From: Speakman, Glenn - Oxfordshire County Council
<Glenn.Speakman@Oxfordshire.gov.uk>
Sent: 07 July 2023 10:52
To: Lewis Knox; DC Support
Subject: 23/00796/DISC Formerley Buzz Bingo, Bolton Road, Banbury, OX16 5UL

OCC **objects** to the discharge on Condition 6 (CTMP) of application no. 21/04202/F.

Drawing title  
Site Setup

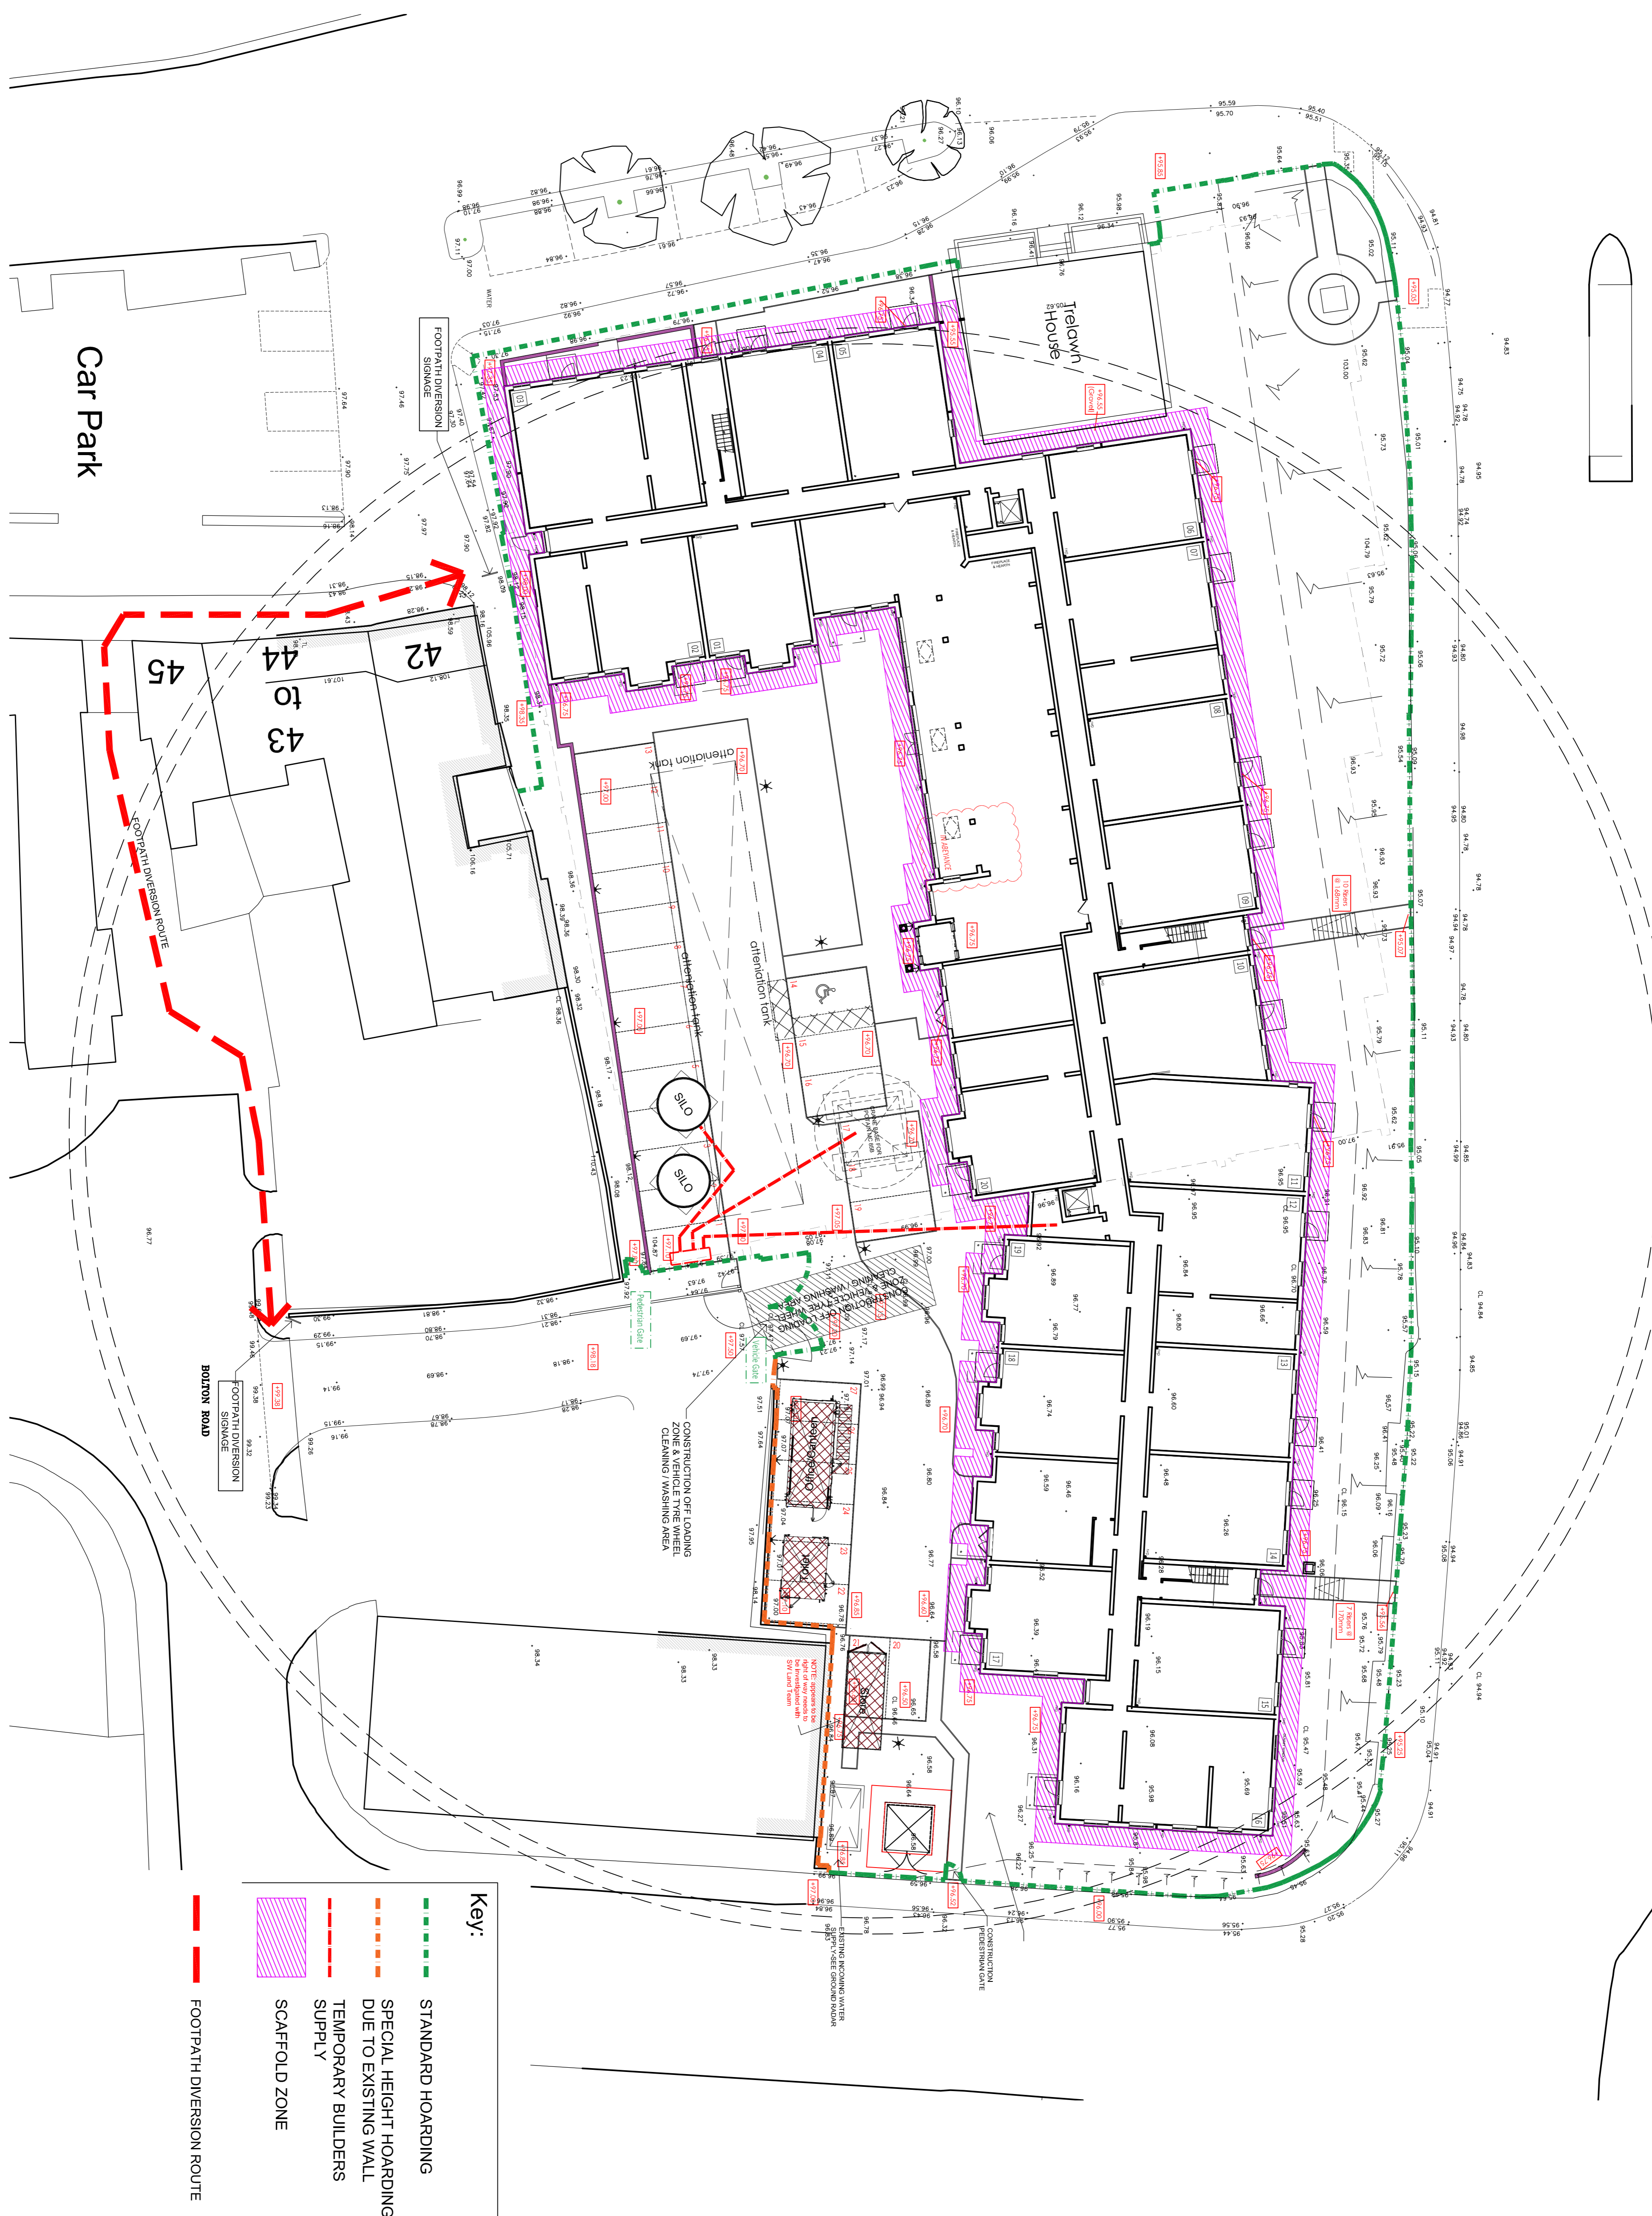
The applicant must also provide a plan of the construction site, with parking for construction workers clearly labelled.
